APPENDIX E – SUBMISSIONS RECEIVED

North Sydney Zone Substation Redevelopment (MP 10_0092) - Submissions

RE: North Sydney Zone Substation Redevelopment (MP10_0092) Environmental Assessment - Exhibition.

**RE: 3-11 WARD STREET, NORTH SYDNEY
PART 3A DEVELOPMENT – DEPARTMENT OF PLANNING
REFERENCE: MP 10_0092**

Figure 9-22 - Northern façade of 136-140 Walker Street and proposed substation

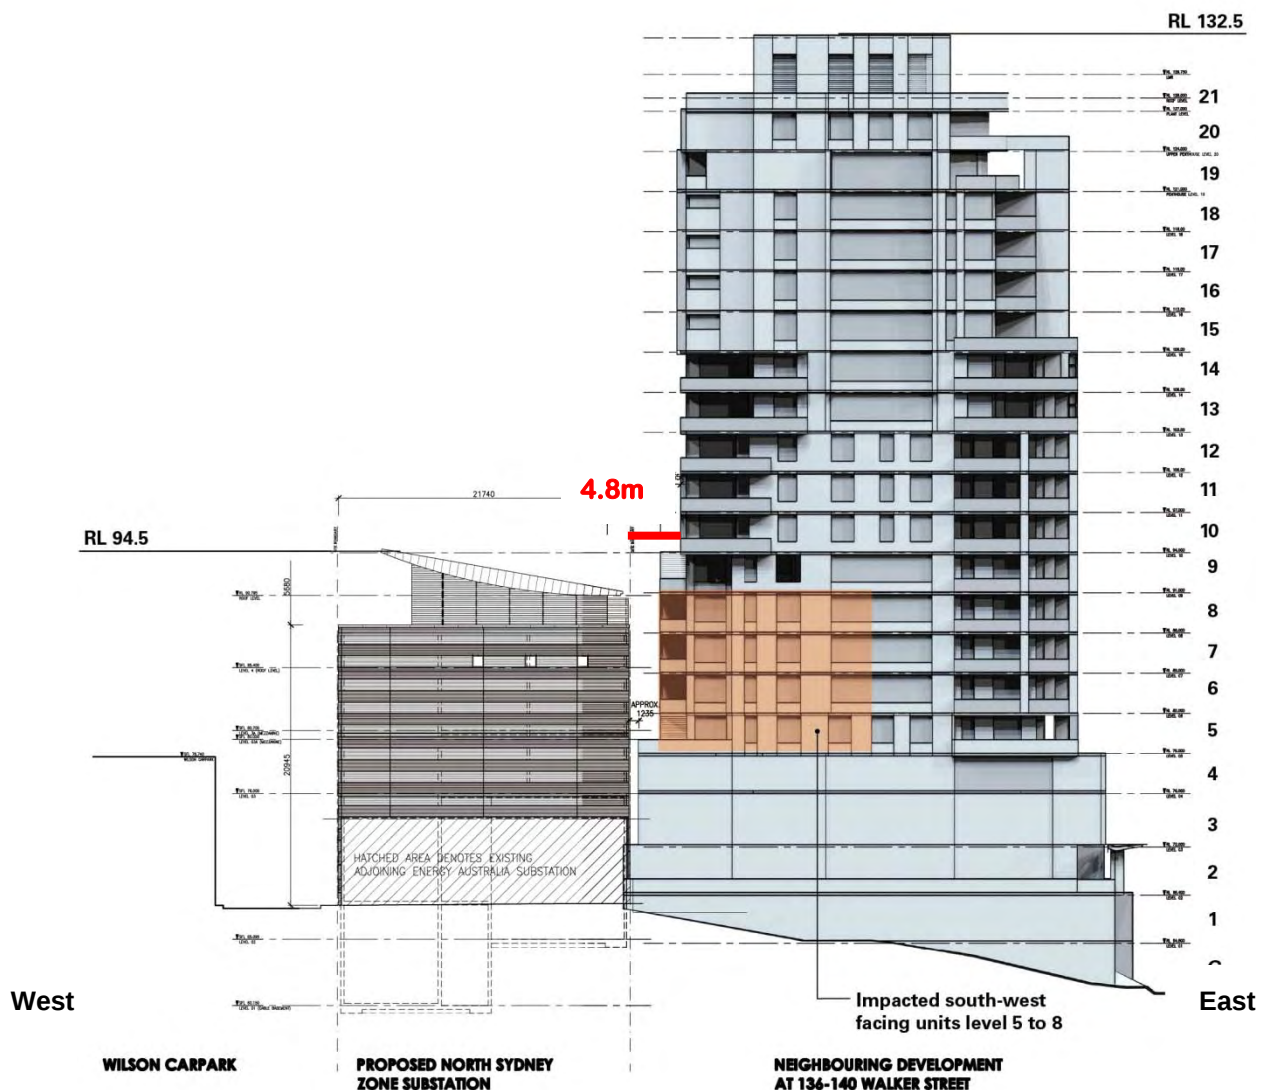
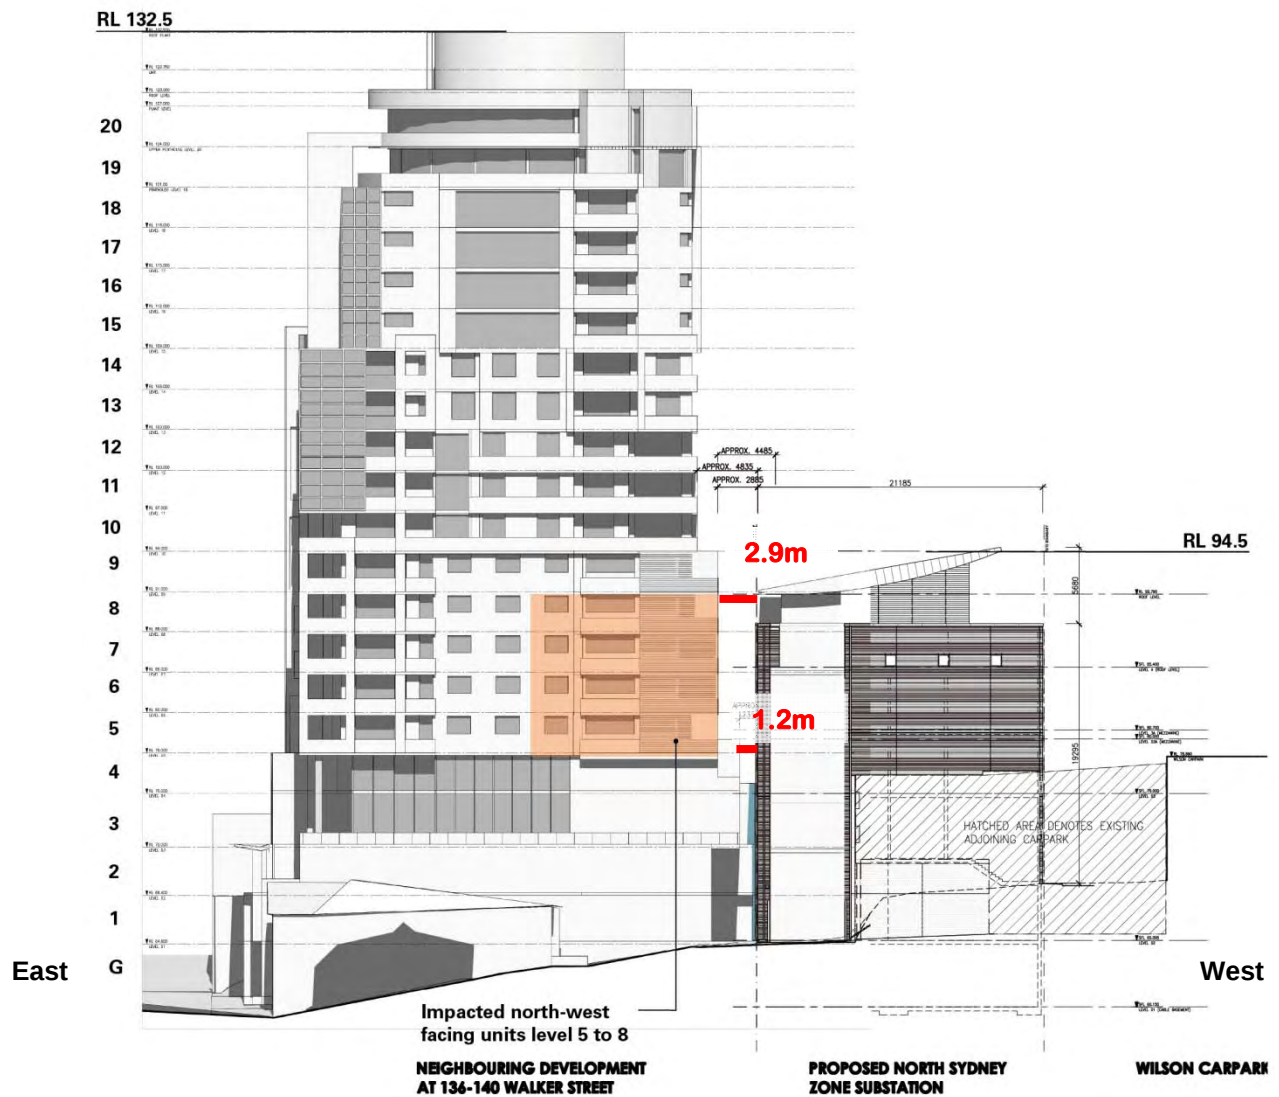
1. The visual impact assessment presented in the Environmental Assessment has considered visual impacts from the new substation to existing residential receptors at 144 -150 Walker Street, however has not specifically considered impacts to the approved mixed use development at this location. The Submissions Report should provide details of the mixed use development approved at 144 -150 Walker Street (including whether any residential floors face the substation) and discuss any potential for visual impacts at this future landuse with consideration to set back distances and potential for over-shadowing.

2. The Submissions Report must document additional investigations undertaken since the Environmental Assessment was placed on exhibition to determine any changes that could be made to the design to further reduce predicted visual and electro-magnetic field impacts at the current approved mixed use tower at 136-140 Walker Street (DA 195/2008).

Figure 9-35 – Predicted magnetic field contribution at Level 2 of the proposed mixed use development (commercial level)

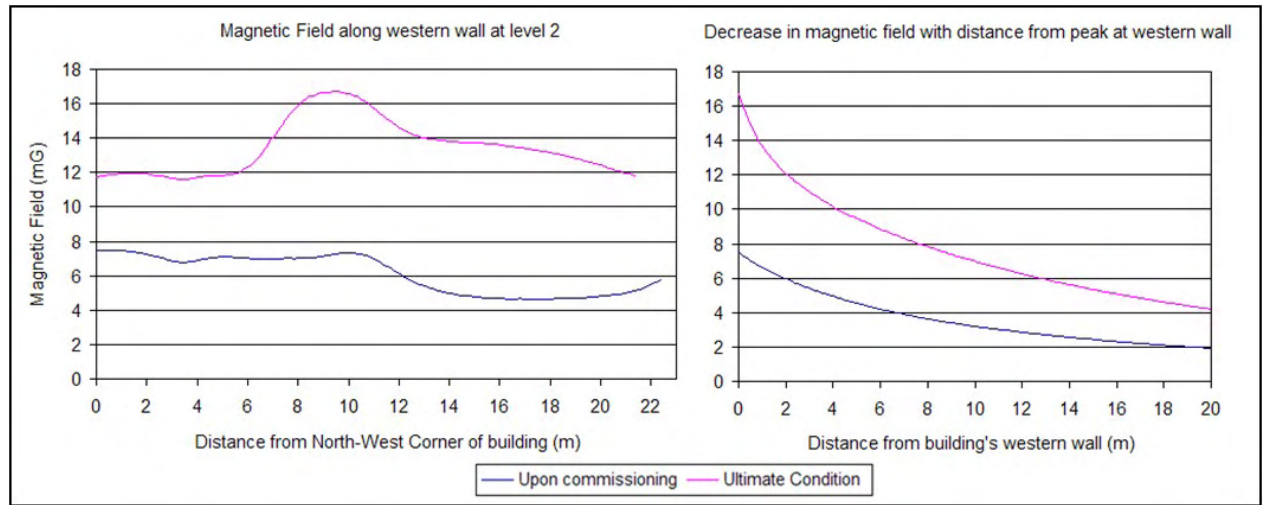
Figure 3.21 predicts that EMF levels for some residences on level 5 will be in the order of 6 to 9 mG and although these levels decrease with distance from the external wall they will still be approximately half of these levels at a distance of 10 metres from the outside wall. These levels are substantial higher than the existing levels of approximately 0.3 mG measured at the boundary.

In summary, the EA predicts that sensitive residential receptors will be exposed to a substantial increase in EMF exposure above currently existing levels if the substation facility is constructed as currently designed. It is recommended that the design of the project should be altered with the objective of reducing this predicted increase over background levels.
